REQUEST

Current Zoning: MUDD-O (mixed-use development district, optional)
 Proposed Zoning: MUDD-O SPA (mixed-use development district, optional, site plan amendment) with 5-years vested rights

The petition proposes a site plan amendment to approved rezoning petition 2021-092.

Exhibit A – General Sign Locations

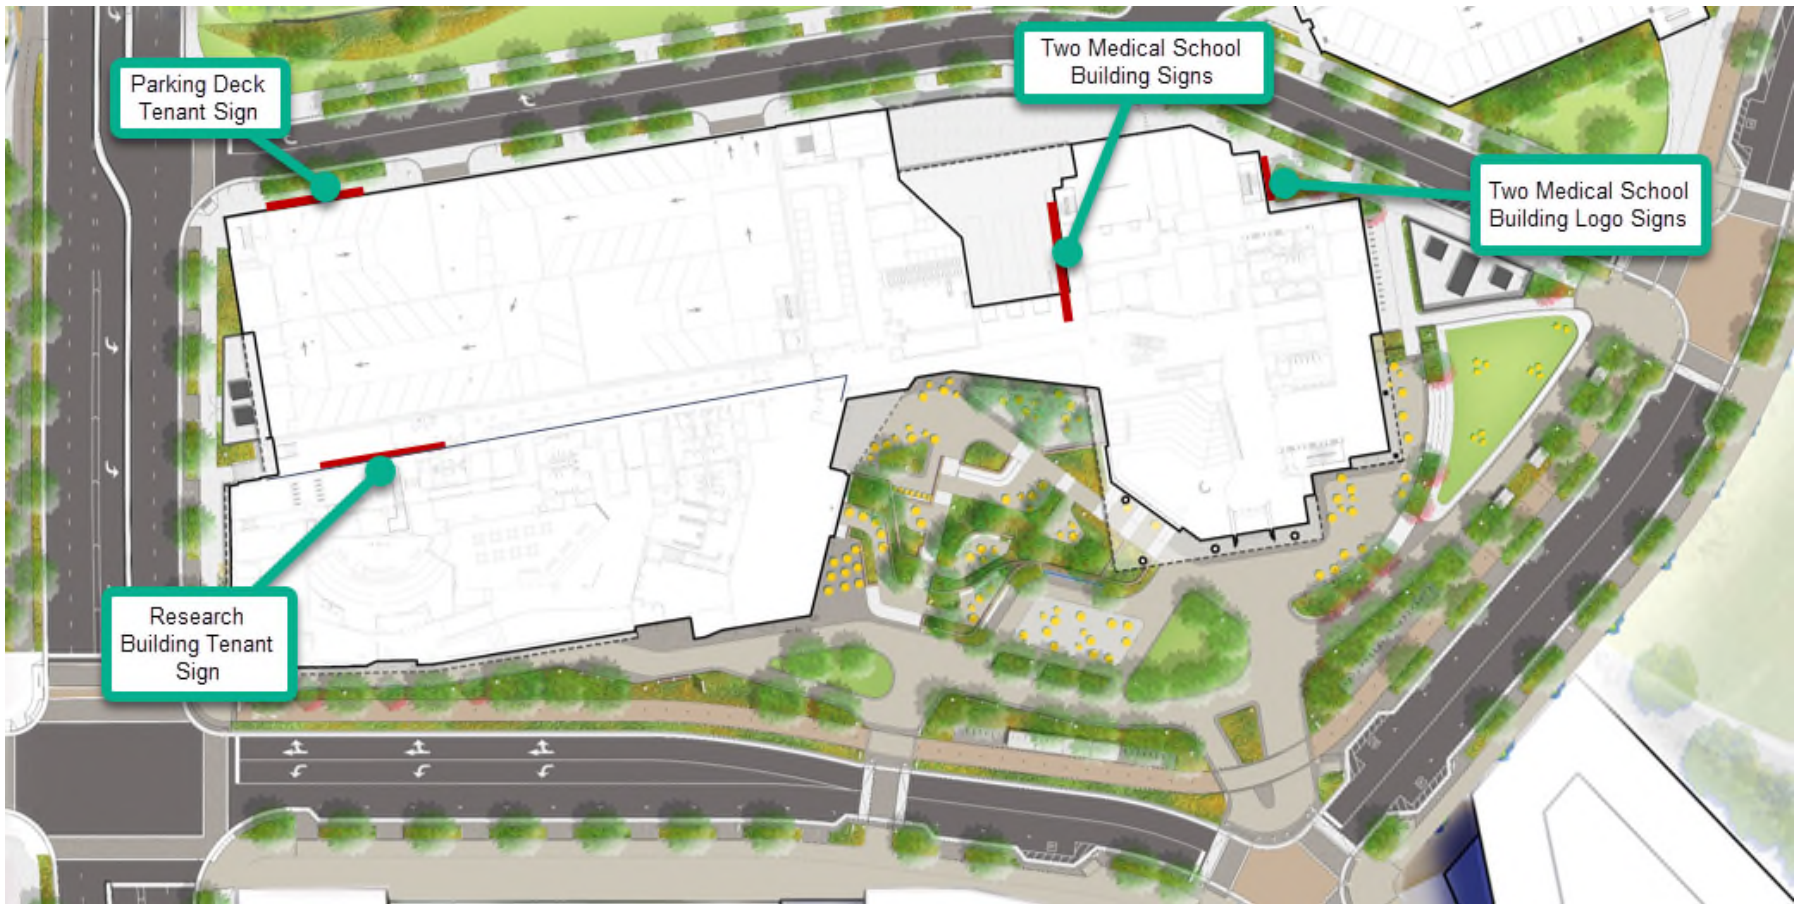
2. Clarify whether the signs proposed in the optional provisions meet the definition of skyline signs or wall signs. Modify as needed.
-

Conceptual Building Section

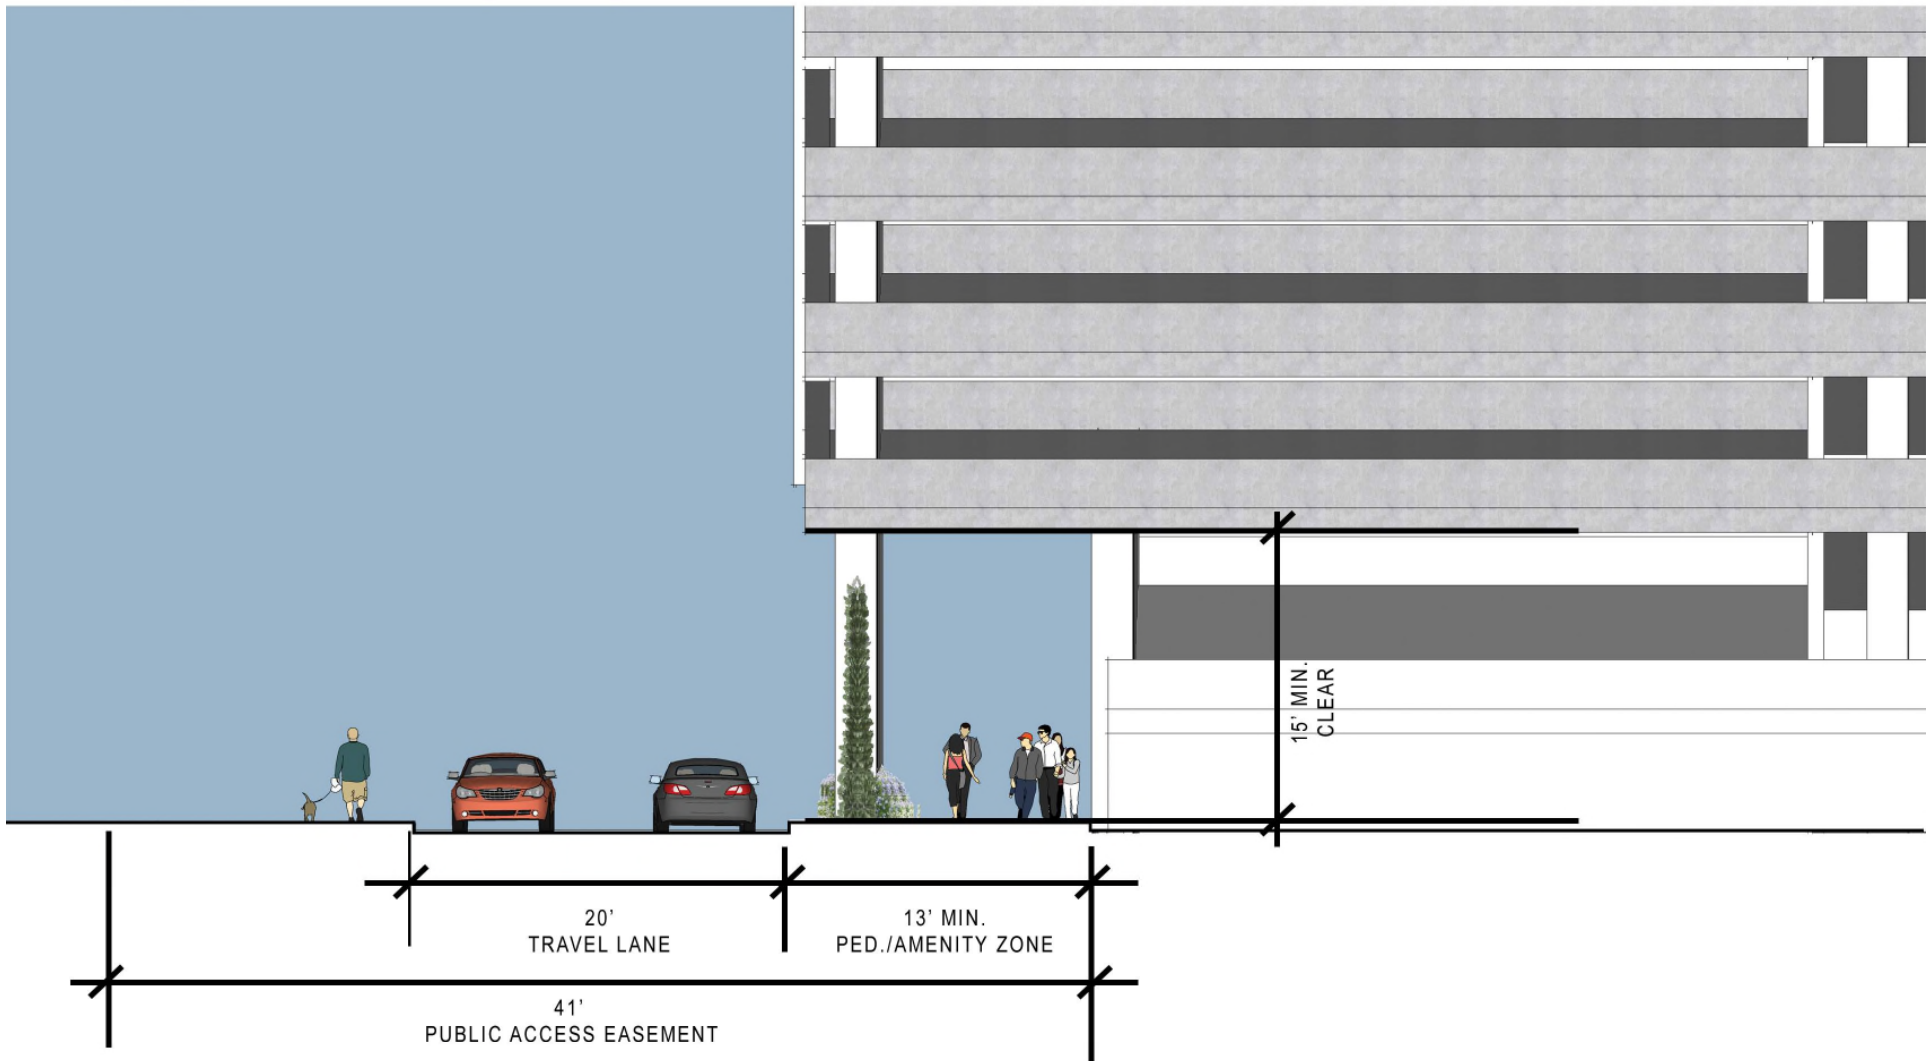
1. Remove item (c) from Section 3. regarding modifications to the setback. Exemptions from required street trees are not an allowed.
